1 SITE PLAN
SP1 SCALE: 1" = 30'-0"

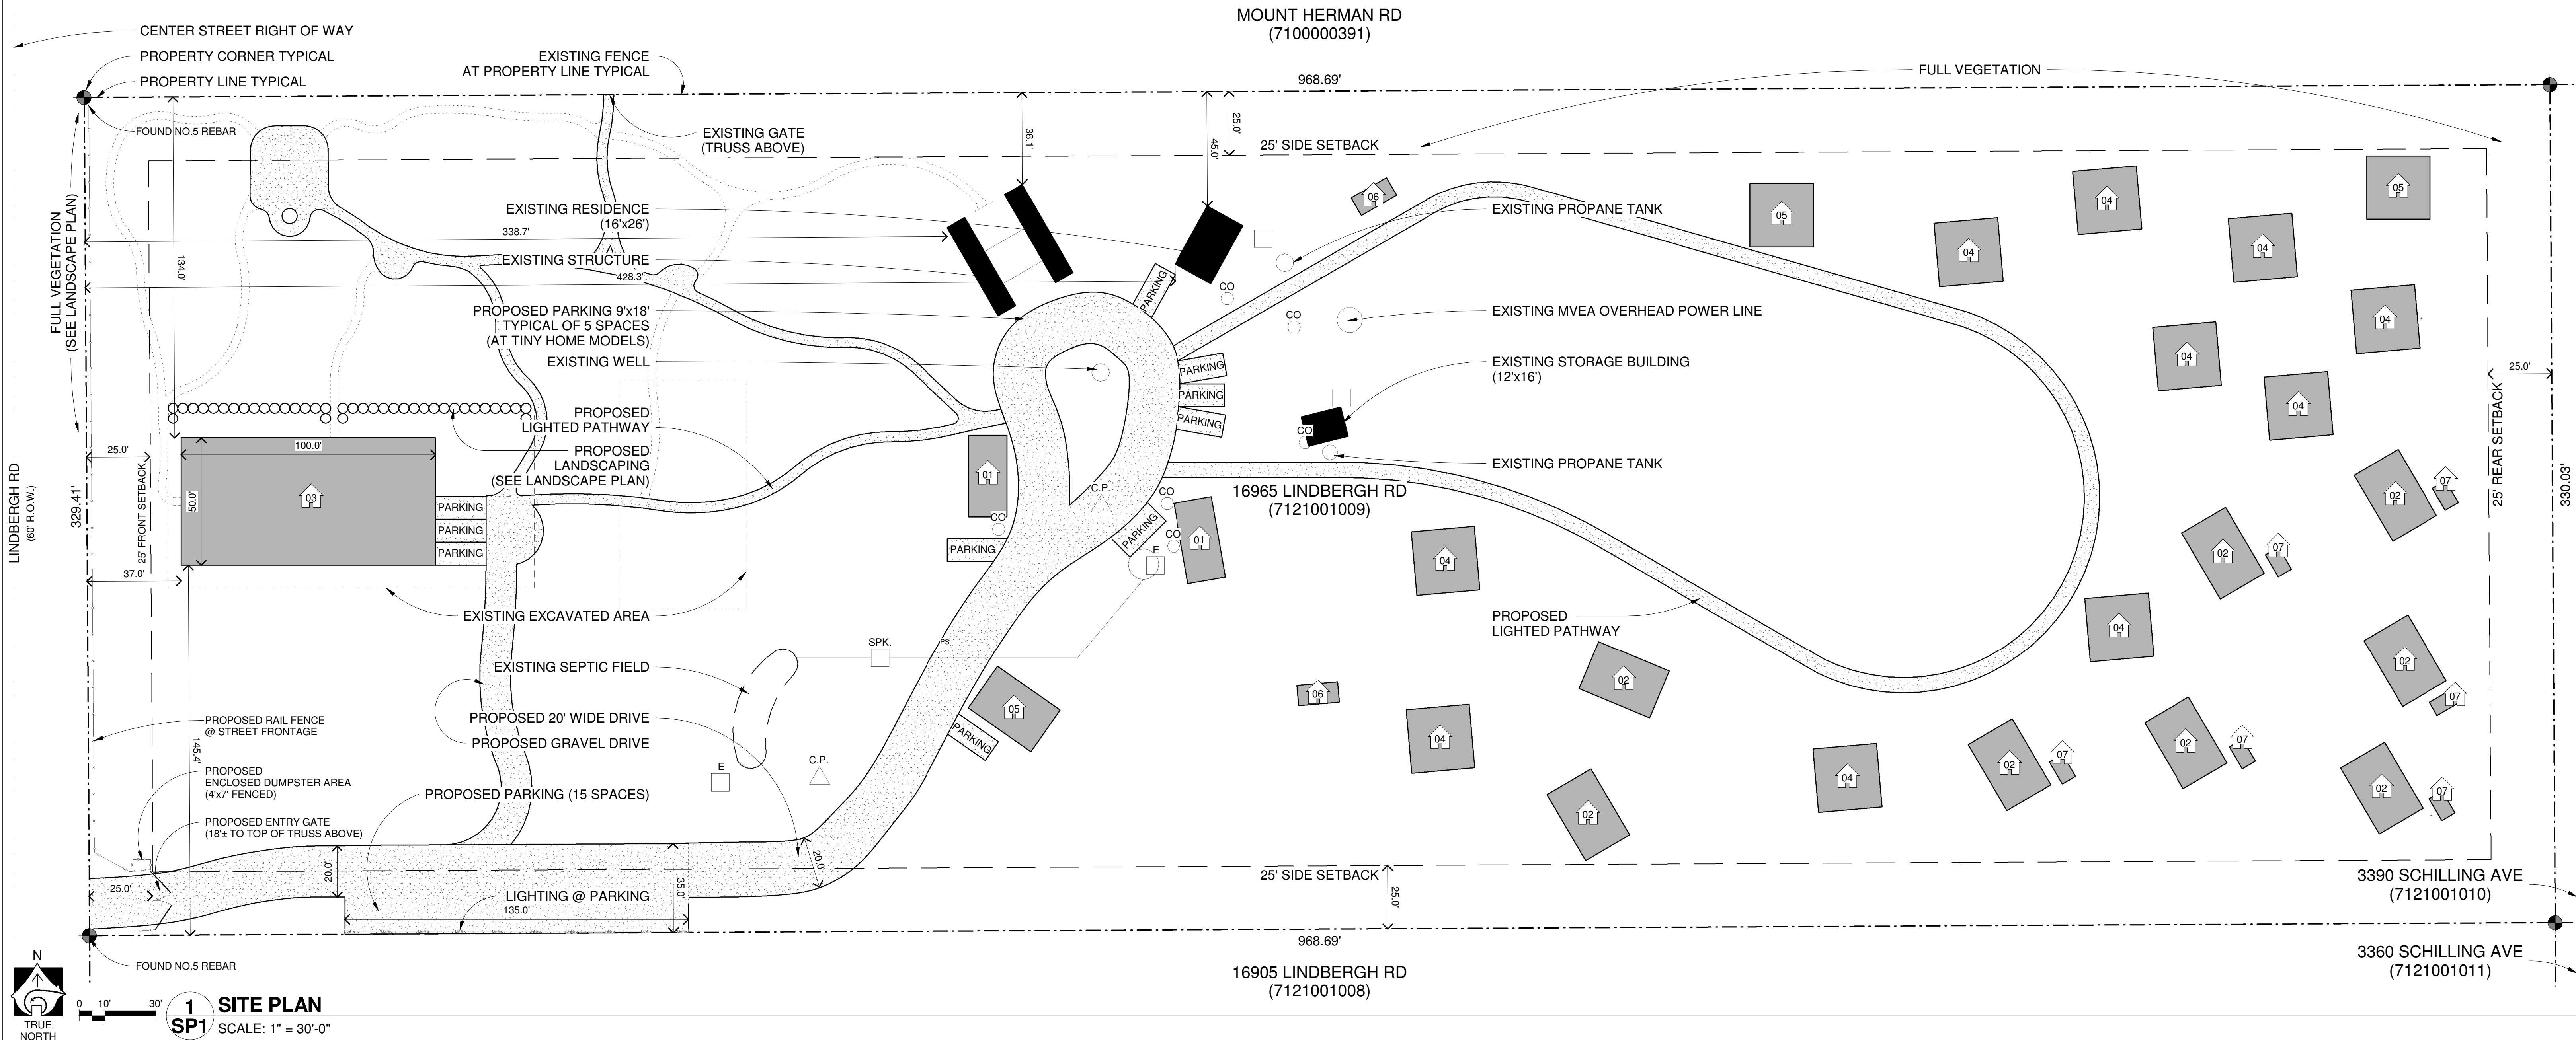
Lighting is not required to be shown on the Special Use Site Plan. This will be a required separate sheet during review of the Site Development Plan (PPR). If you want to remove it from this page, that would be fine!

Please verify with US Forest Service (kimberly.wilkes@usda.gov) that this is allowed.

Please label

Include linework in legend (property line, easements, setbacks)

Please include legend or clearly label site elements (a few examples highlighted)

Please label as:
Public minor collector, prescriptive 60'
ROW

See EDARP comment with driveway/"non-road" access Code. Minimum width is 24'.

A comment was made over the phone that there will be a reduction to the number of proposed glamping sites.

The Fire Protection District has concerns regarding parking area obstructing the emergency access road along the southern property line. They are also requesting a secondary emergency access point/ driveway - please talk with JosephSandstrom@elpasoco.com about secondary access. Emergency access needs to be provided to all glamping sites.

Minimum access width for 2 way commercial access is 25'. This will need to be revised with the Site Development Plan.
